Land adj. Tern Inn, 1 Heron Way, Chipping Sodbury BS37 6XW

I write in respect of the above site, which benefits from extant planning permission from November 2022 for the erection of a convenience store with 9 no. flats above, with associated access and parking (LPA Ref: P/21/06188/F).

Following discussions with the convenience store operator, local residents and Dodington Parish Council the applicant wishes to make several minor amendments to the approved plans and documents. Accordingly, the applicant hereby applies for a minor material amendment by virtue of the provisions set out under Section 73 of the TCPA 1990.

Client	GREEN CITY HOMES
Project	MIXED USE DEVELOPMENT, HERON WAY, CHIPPING SODBURY
Drawing Title	LANDSCAPE PROPOSALS
Drawing Status	Planning
Scale	1/125 @ A1
Drawn By	17/25 @ A1
Drawing No.	2319/1K
Date	23 Jun 22

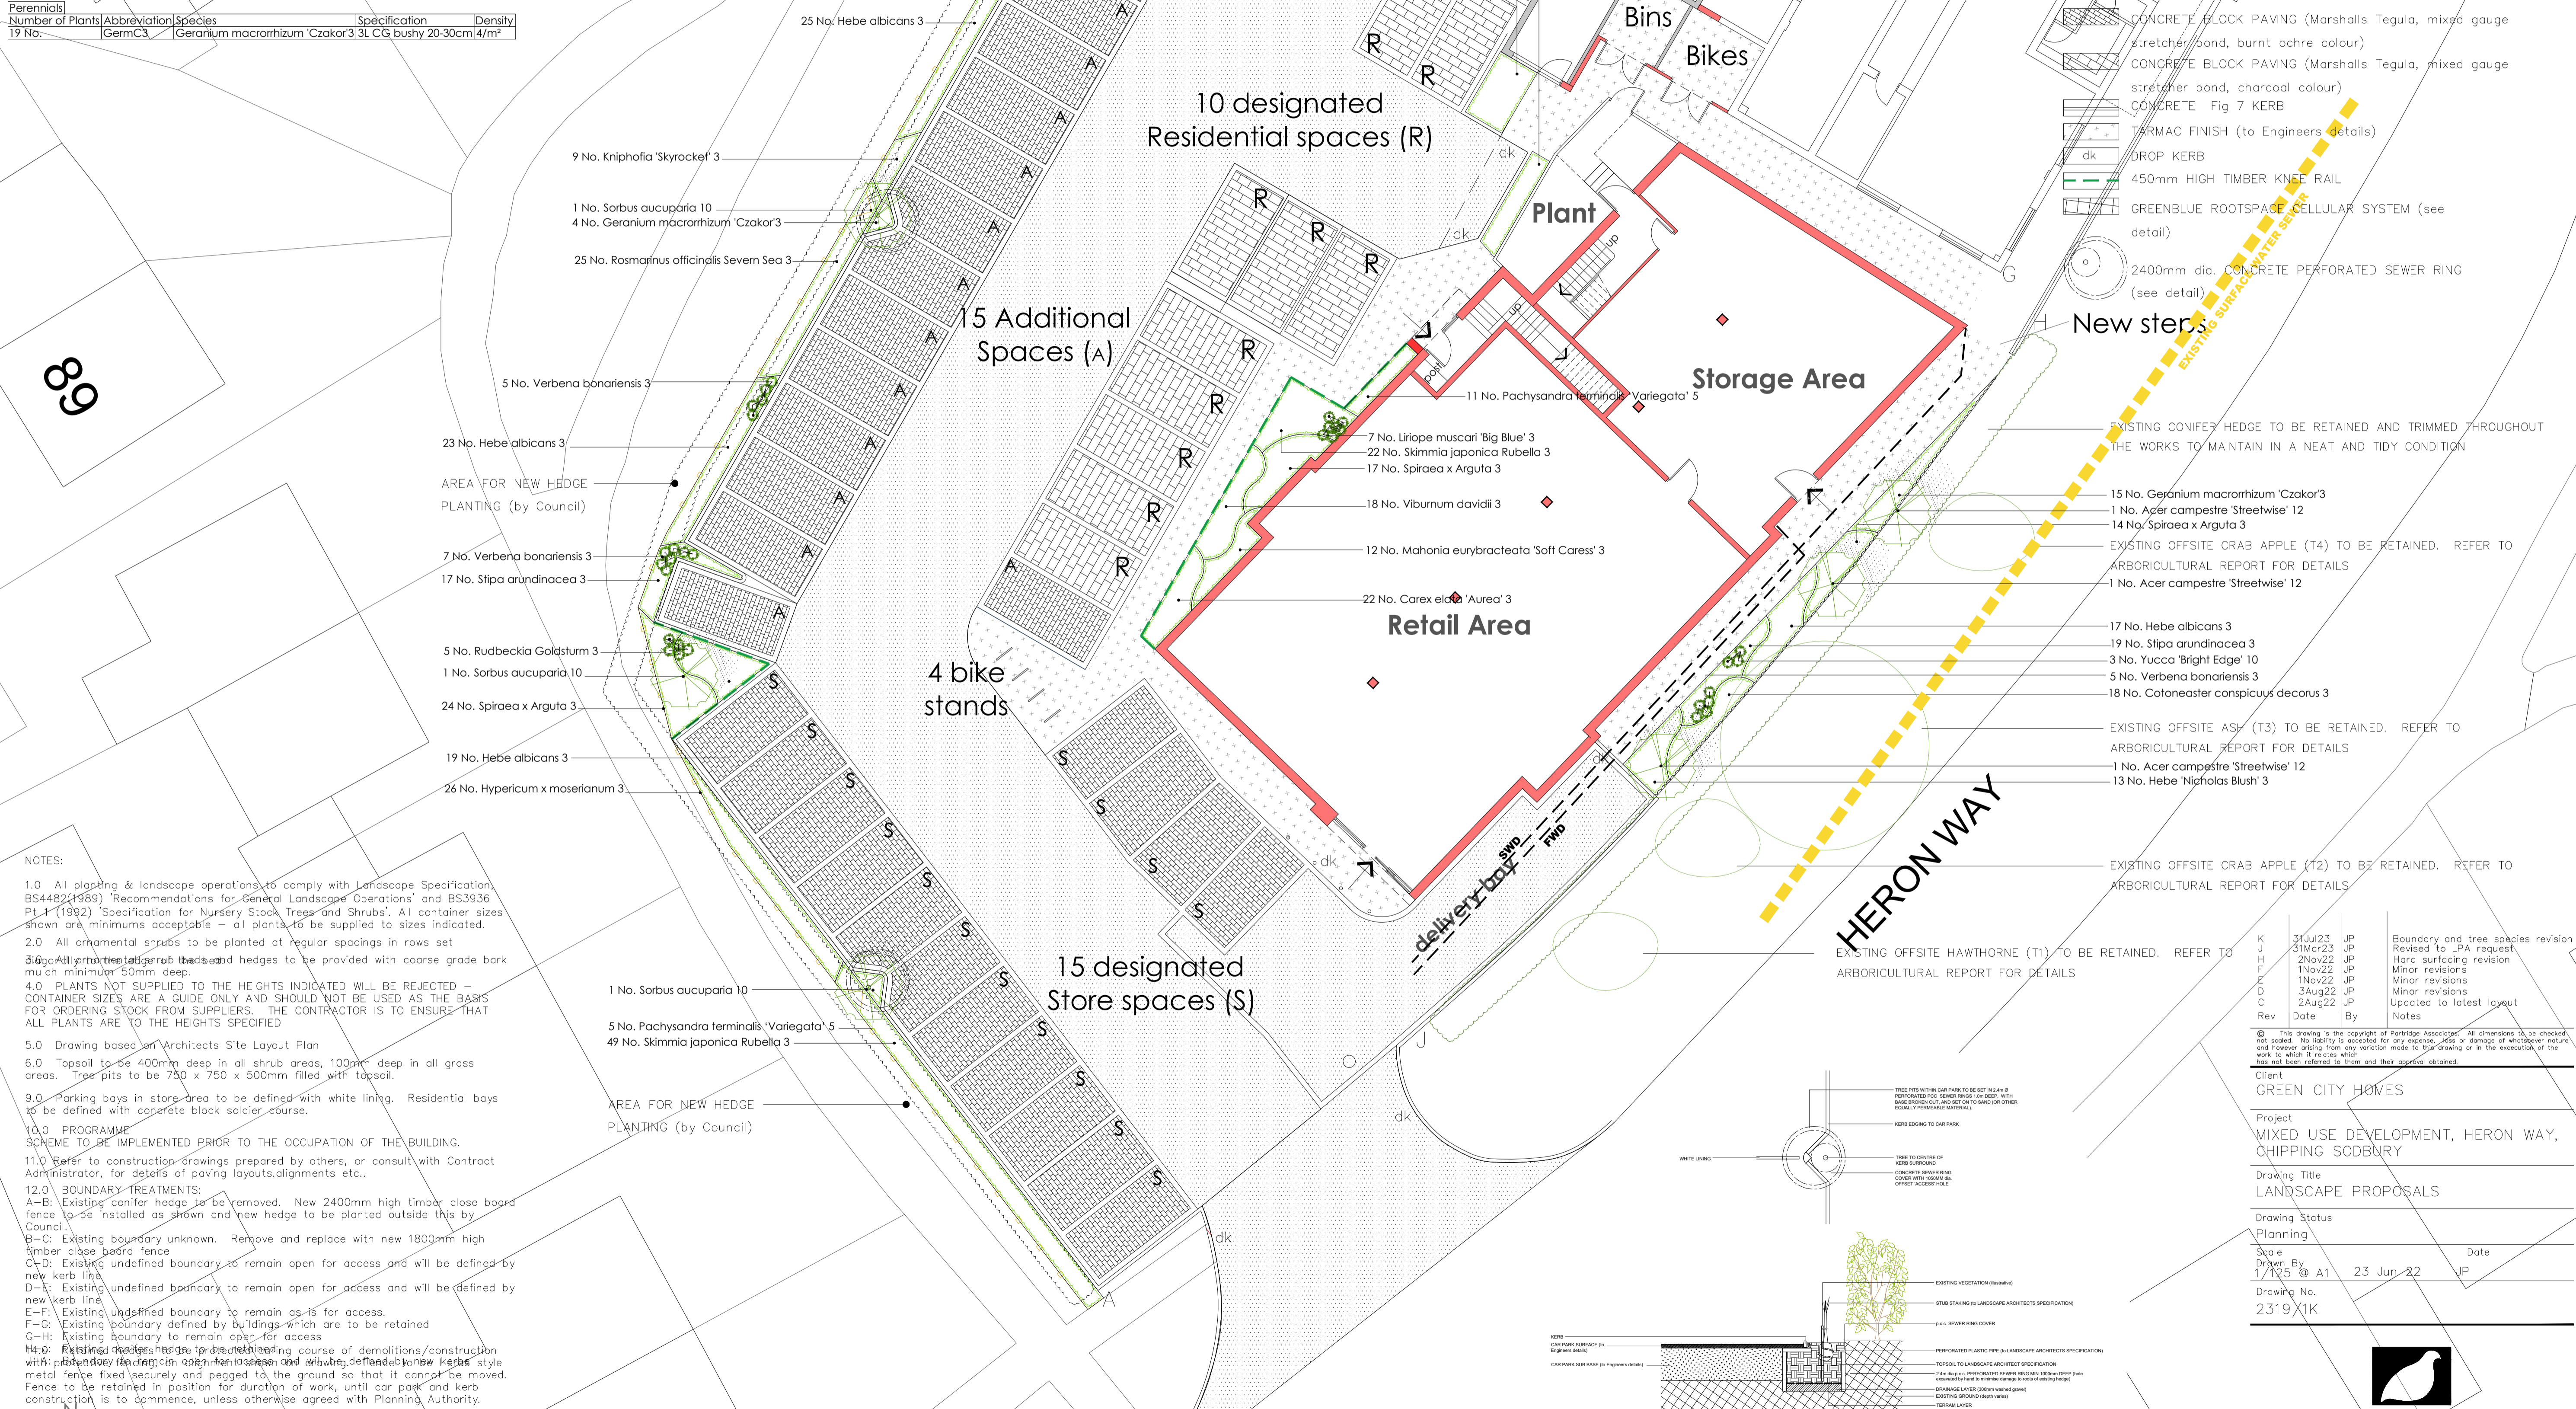
- 1. Boundary changes** – Due to the size and depth of the existing boundary hedge, it has been discovered during the construction works that the initial topographical survey was inaccurate, which necessitates changes to the approved site plan and landscaping plan.

If the development was to be completed in accordance with the approved plans, large areas of the existing hedge would need to be removed to provide the car parking area. This would create a patchy hedge with irregular trunks, which would have an unsightly appearance and fail to provide necessary screening for neighbouring residents.

The applicant has met with the neighbouring residents and Dodington Parish Council to discuss this issue. It is proposed to remove the existing hedge to facilitate the parking area and plant shrubs along the site boundary, which would be enclosed by a new fence. Behind the fence (outside of the red line), a new hedge will be planted by Dodington Parish Council on the land controlled by the Local Authority. To this regard, the Parish Clerk has made enquiries with South Gloucestershire Council's licensing team to obtain a permit for the works. It is understood that a license will be given when the amendments to the planning permission are approved.

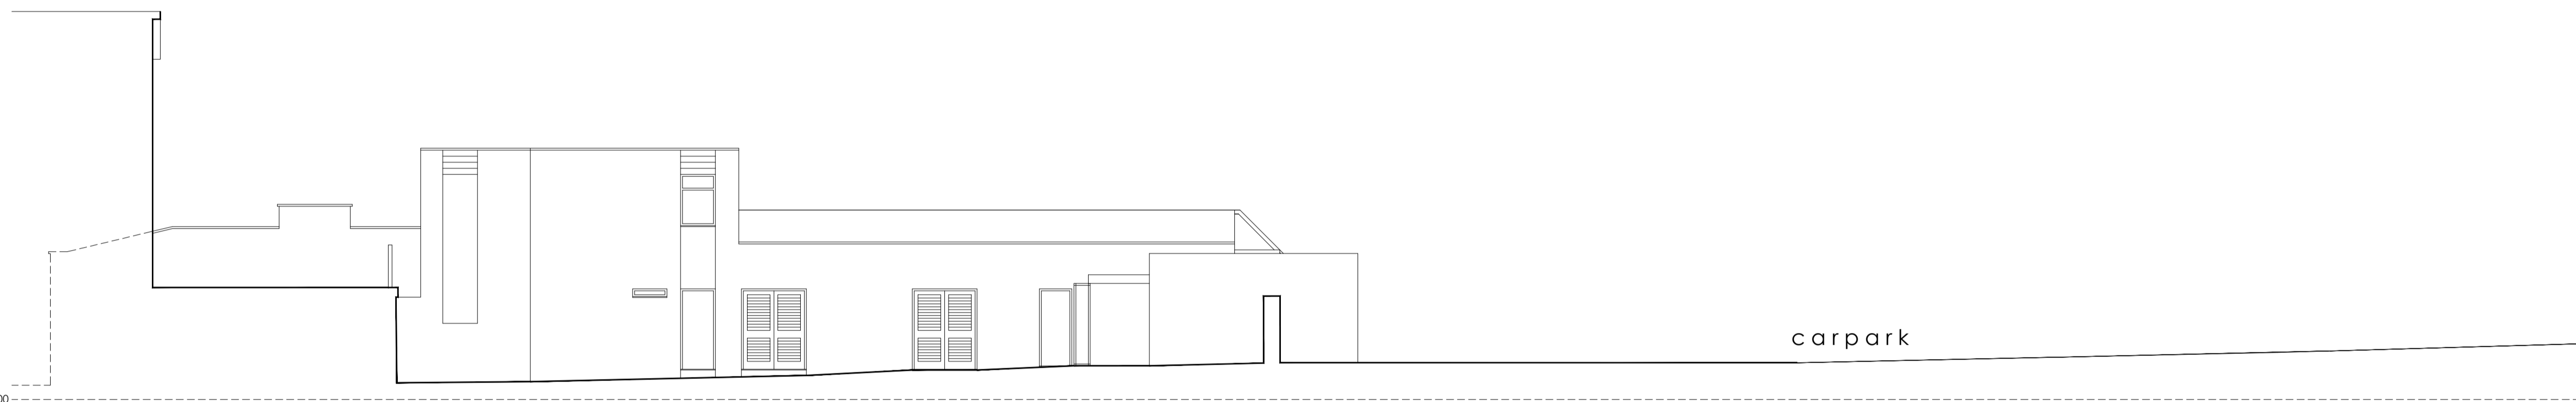
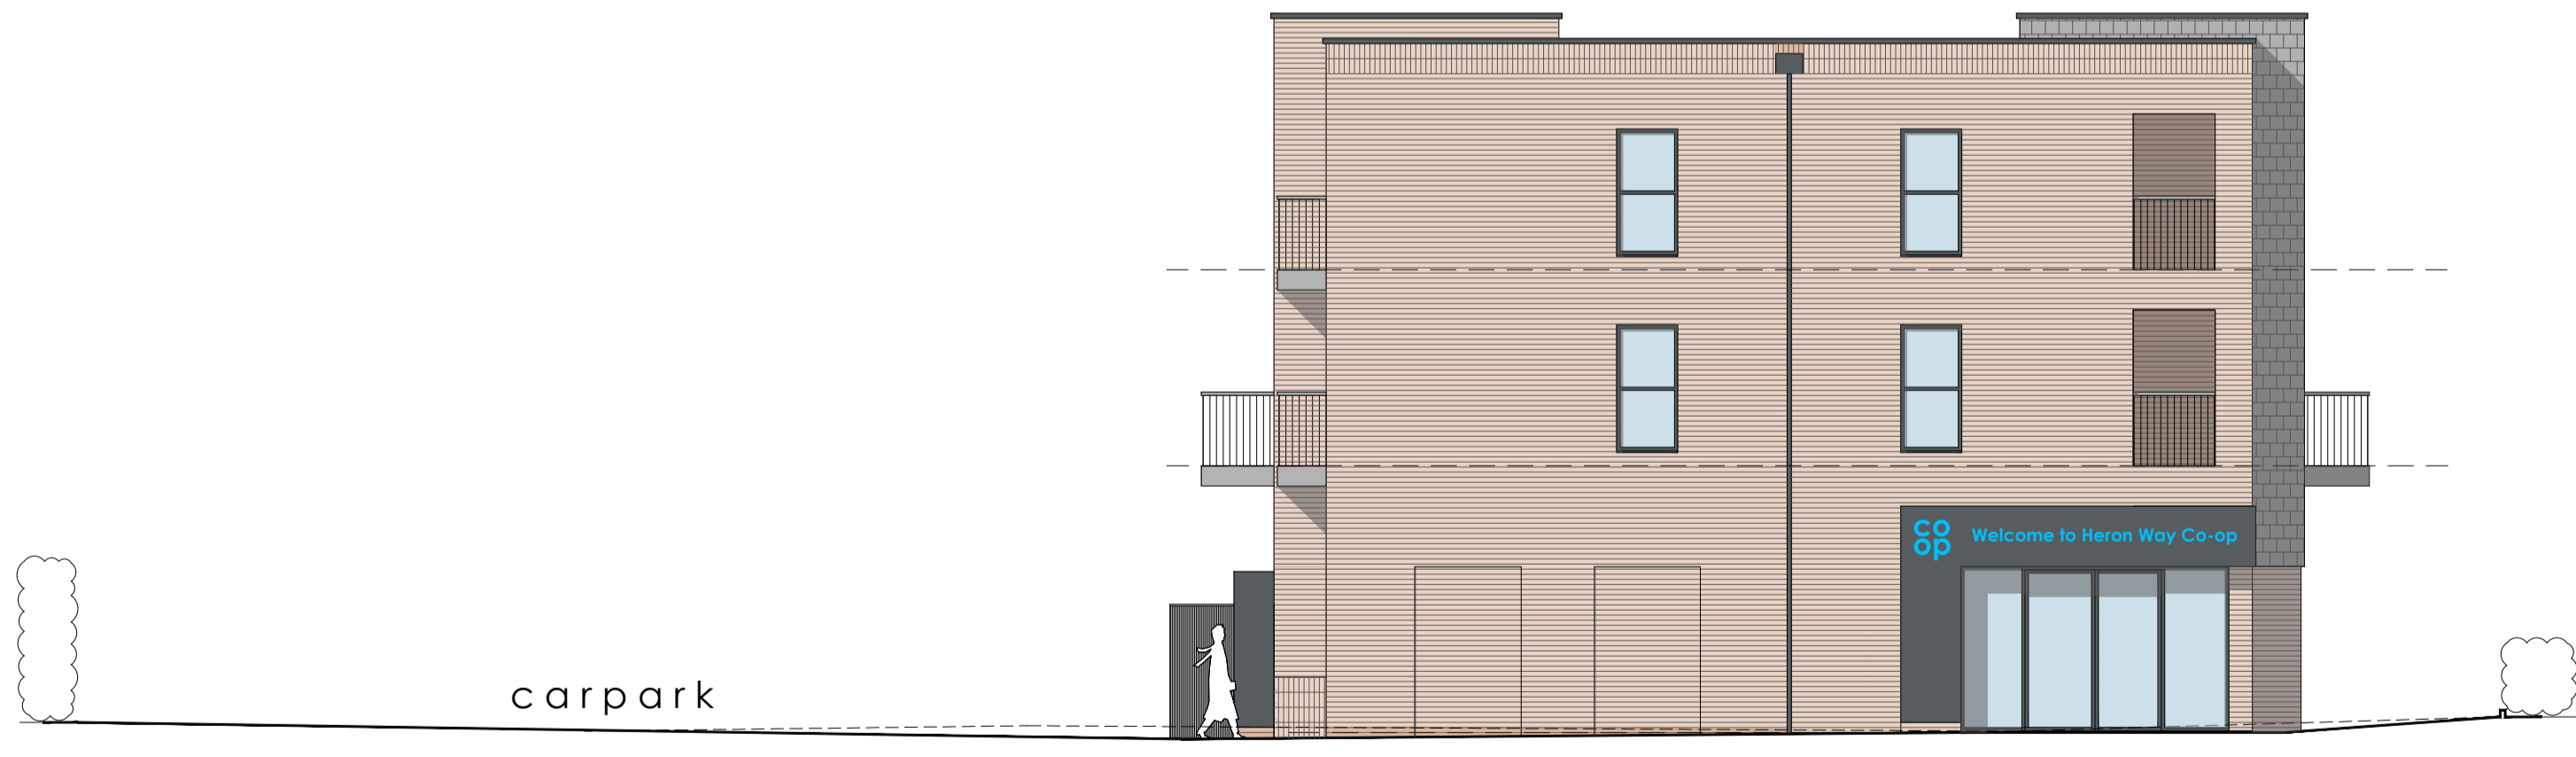
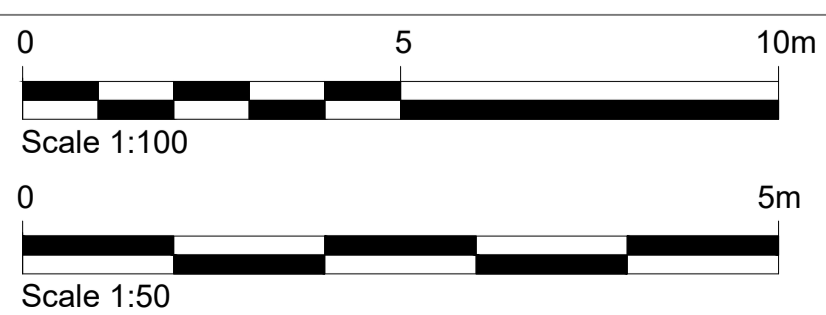
4. **First Floor Back of House** – Two first floor windows have been added to break up the massing of the northwest elevation and improve ventilation within this space.

5. **Utilities** – The required gas meters and water pipes are to be installed on the northwest elevation of the building. Therefore, a secure cupboard needs to be installed to the side of the entrance door. The approved entrance canopy will be extended to provide cover to the cupboard area. In addition, the external downpipes will be enclosed with cladding. The service cupboard and cabinet will be finished in RAL 7016 Anthracite to match the residential windows.
